HUME COAL PROJECT SSD 15_7172
SUBMISSION ON ENVIRONMENTAL IMPACT STATEMENT
Prof. T. M. Romberg FIEAust CPEng(Ret)

Based on my experience on the WAG and my review of the Hume Coal EIS and other expert reviews, **I am objecting to approval of this Project** because of:

The maximum water table drawdown as a result of the project is predicted to occur in year 17 and is illustrated in Figure 7.9.

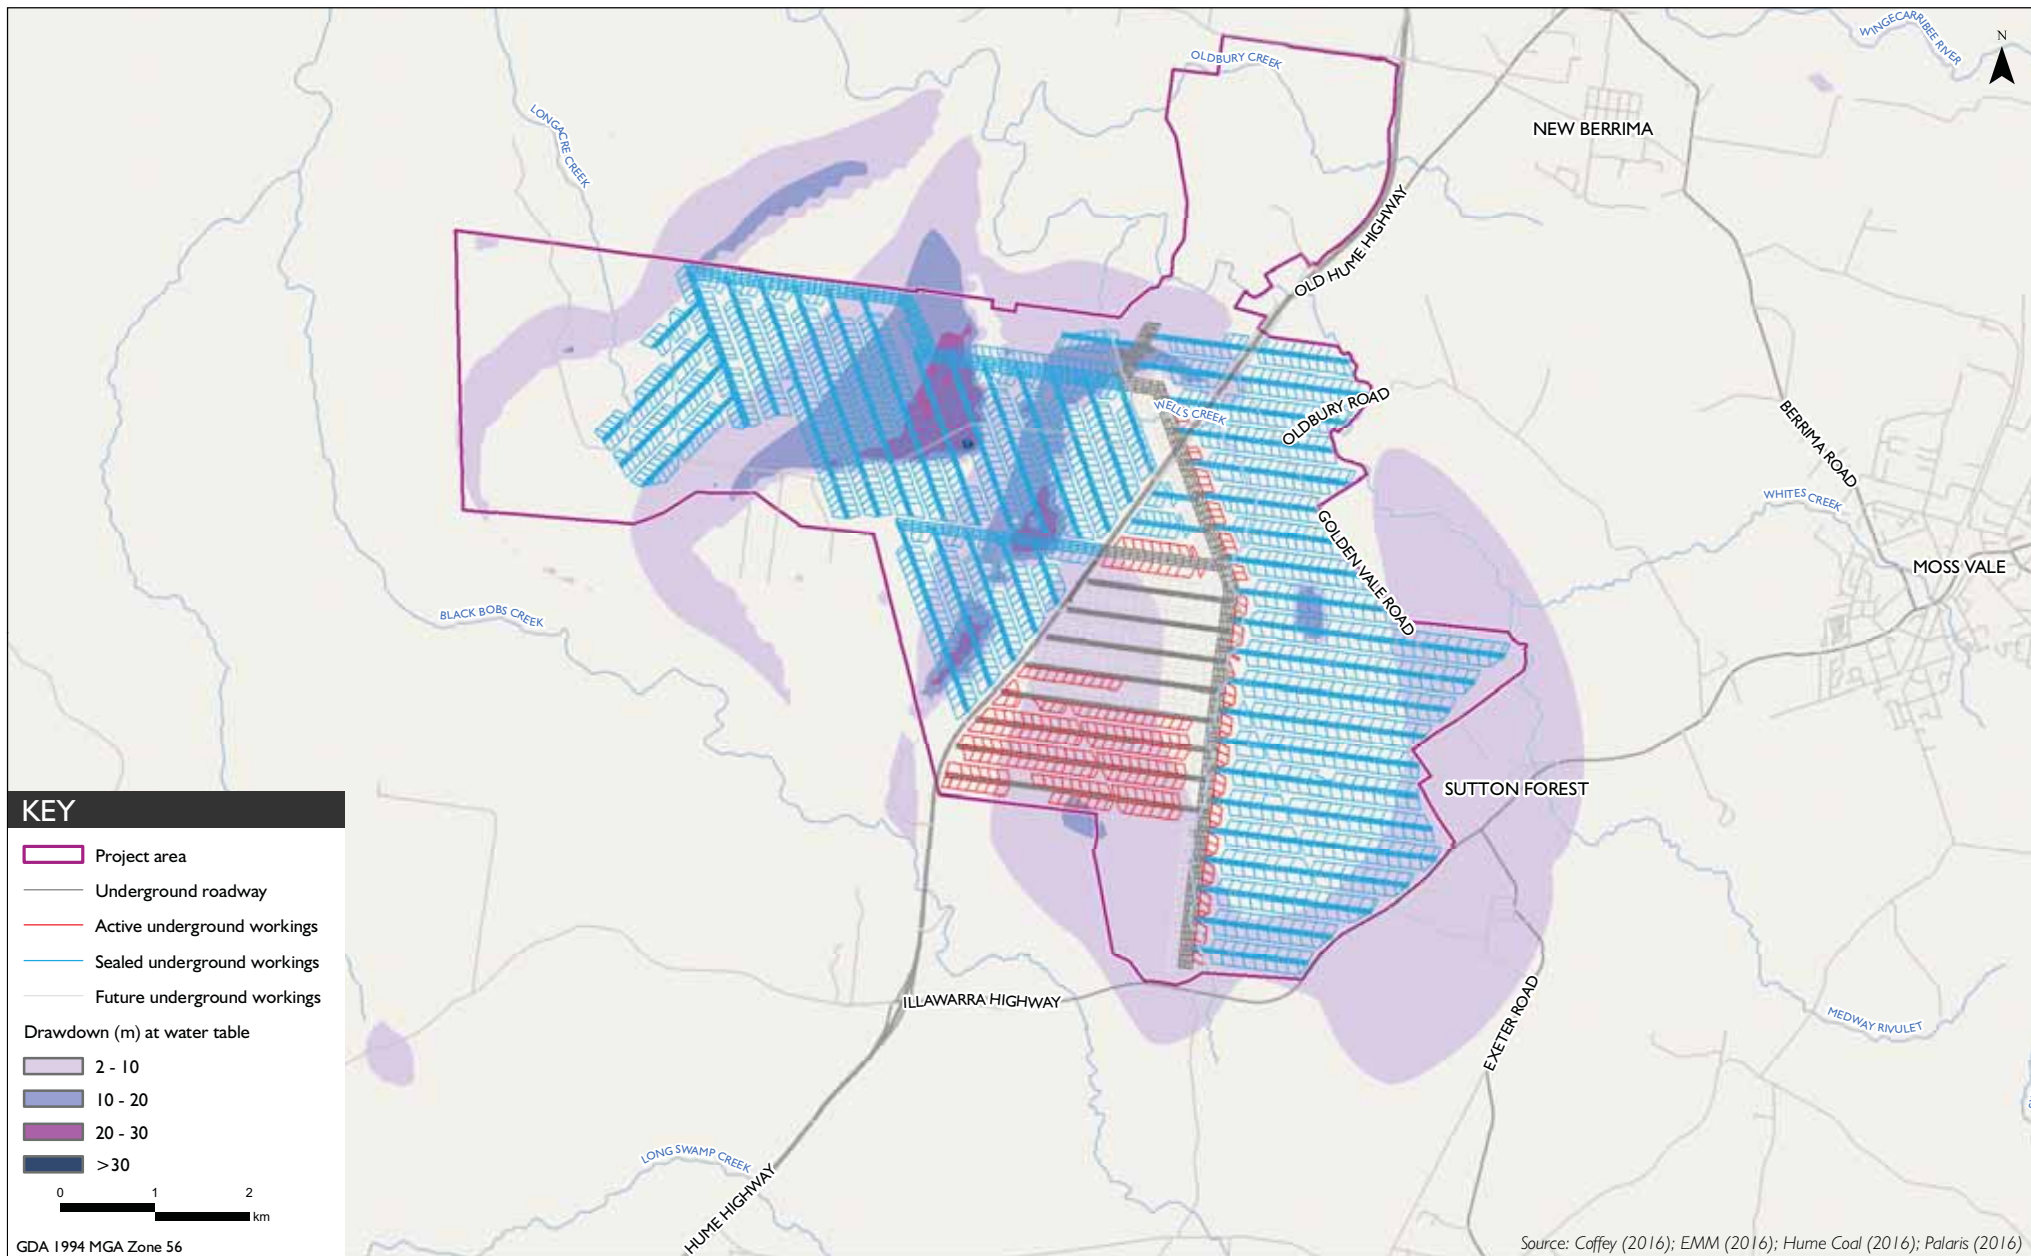
Groundwater Drawdown: The same criticism applies to the modelled Project induced groundwater drawdown at Year 17 of mining shown in Figure 11.1 [4] of the EIS, which is also considered to be a very conservative prediction of the drawdown. This prediction also needs to be confirmed by more a robust modelling study as per the IESC advice.
